East Anglia TWO Offshore Wind Farm

**Natural England's Terrestrial Ecology Update and Comments to Documents [REP3-031,
REP4-004, REP4-005, REP4-015 and REP4-043]**

Planning Inspectorate Reference: EN010078

3rd February 2021

m

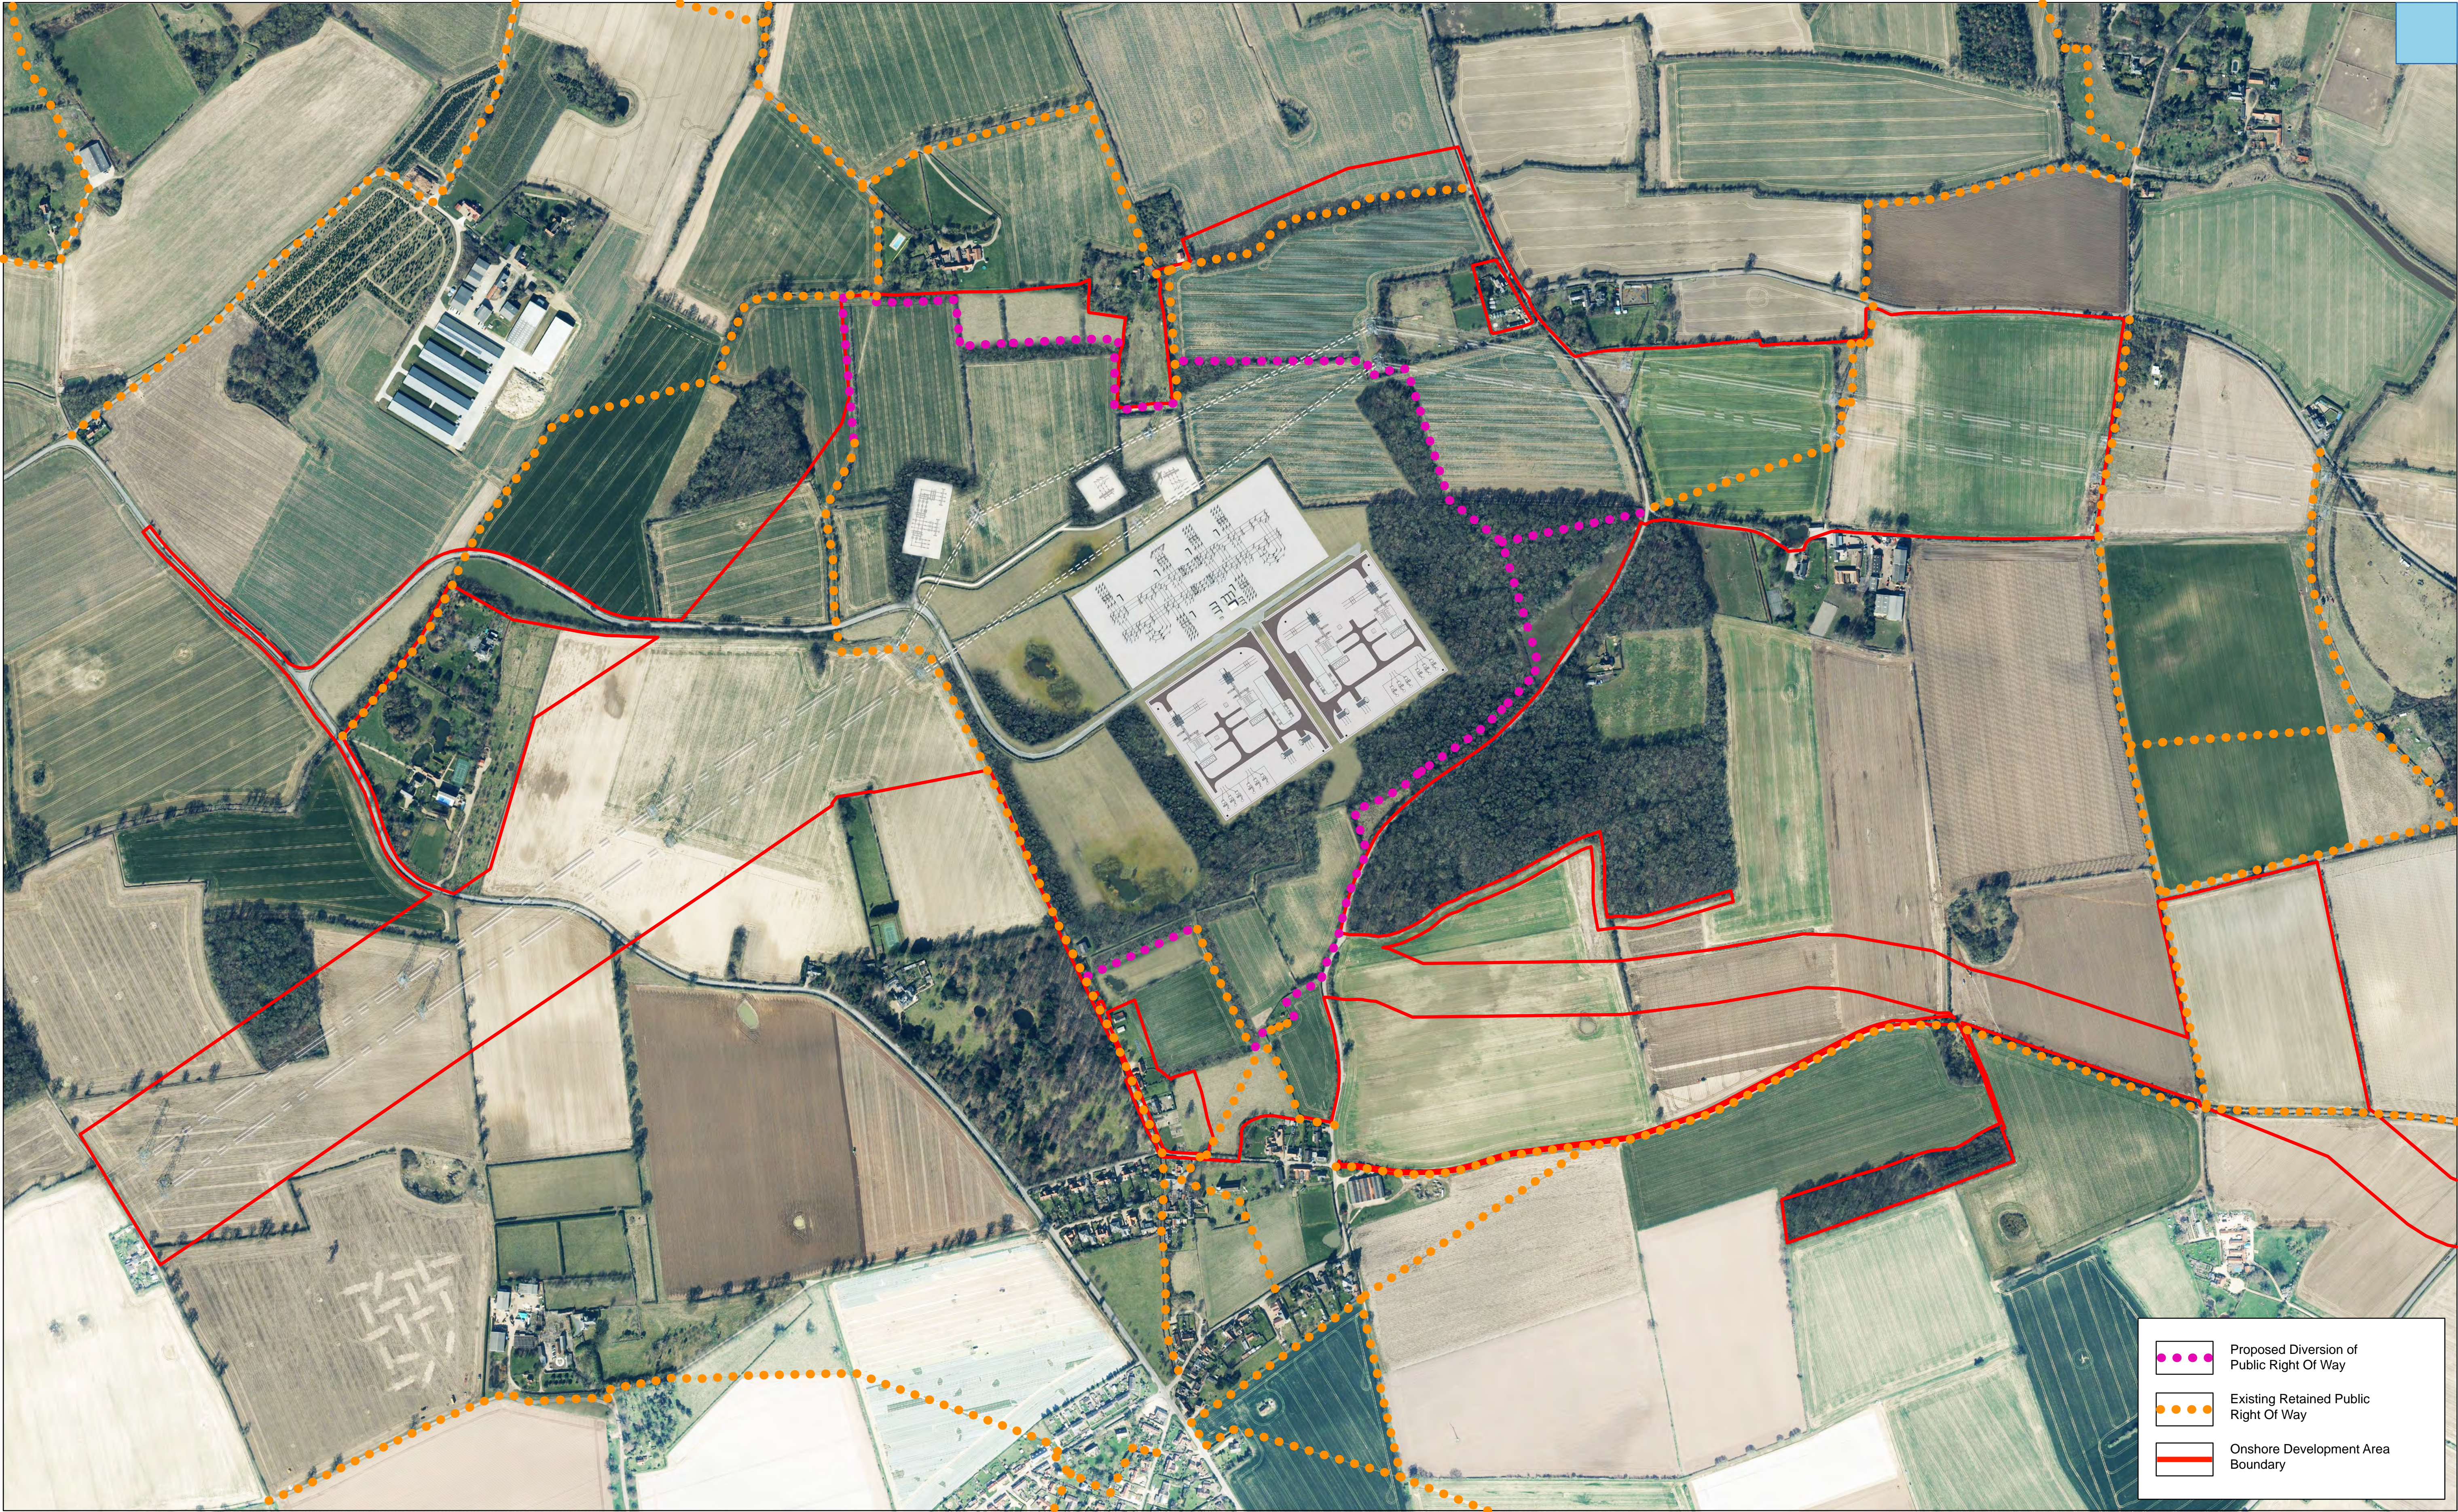
12. We welcome the woodland retention, additional woodland planting and the proposed increased density of tree planting outlined in 45 (3.1.4) Amendments to the OLMP. However we are now aware that there is an area of deciduous woodland, which is Priority Habitat, adjacent to the Hundred river crossing (see comments in paras 7 and 8 above). Natural England is surprised this habitat has not been picked up during the phase one habitat survey, or included within the mitigation plans, and request that this habitat is assessed and added to all relevant documentation.

30. Natural England have no specific comments regarding this plan other than to remind the Applicant that the Priority Habitat next to the Hundred River Crossing is likely to need to be included within this plan. See comments regarding the proposed mitigation and enhancement in our comments regarding the OLEMS.
